**Consultation Response from KC,
Highways Development Management****2020/91522 rear of, 8, Grove Terrace, Birkenshaw, BD11 2LY****Erection of detached dwelling with associated parking****Date Responded: 21/07/20 Responding Officer: J Turner Responding Ref: K8-10NW/13**

PROPOSED SITE PLAN

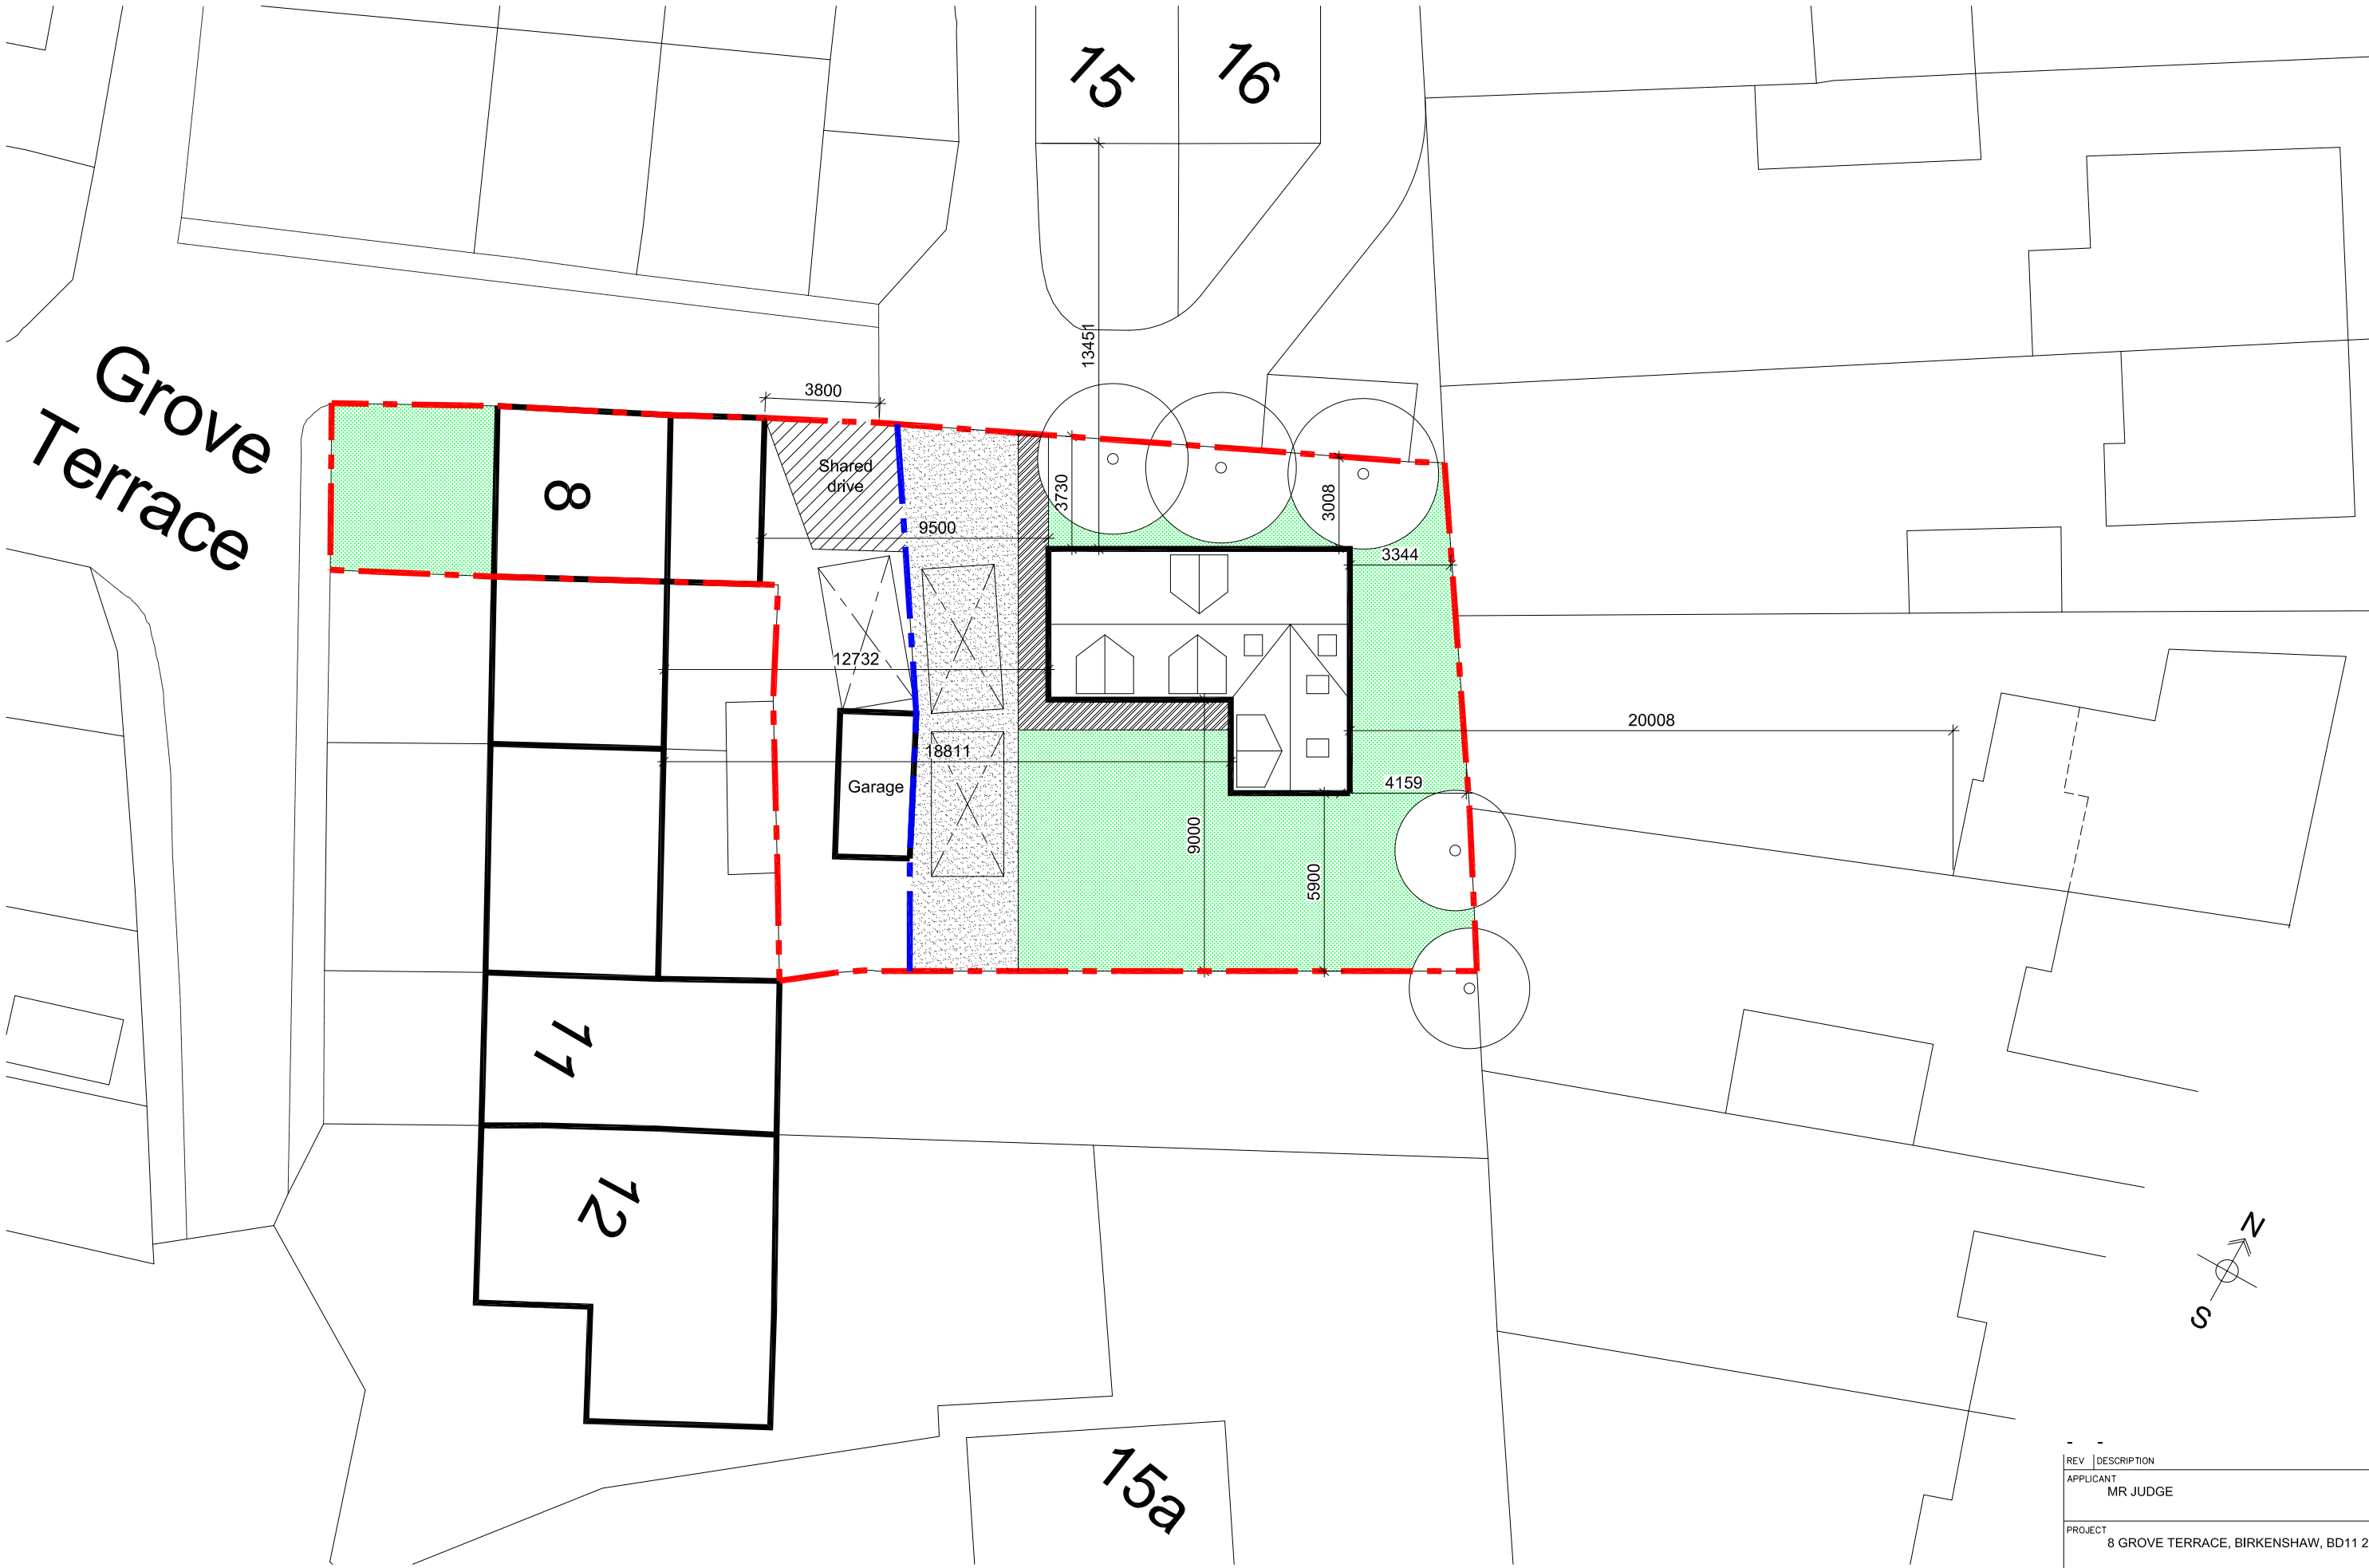
The proposed dwelling would be erected in the garden of 8 Grove Terrace, would consist of three bedroom, and benefit from two off-street parking spaces on a driveway accessed by a shared route that serves the garage of the existing property.

Highways DM would raise concerns regarding the intensification of use of Grove Terrace and its access with Bradford Road, a likely increase in the demand of on-street parking, and the awkward manoeuvre into and out of the proposed driveway.
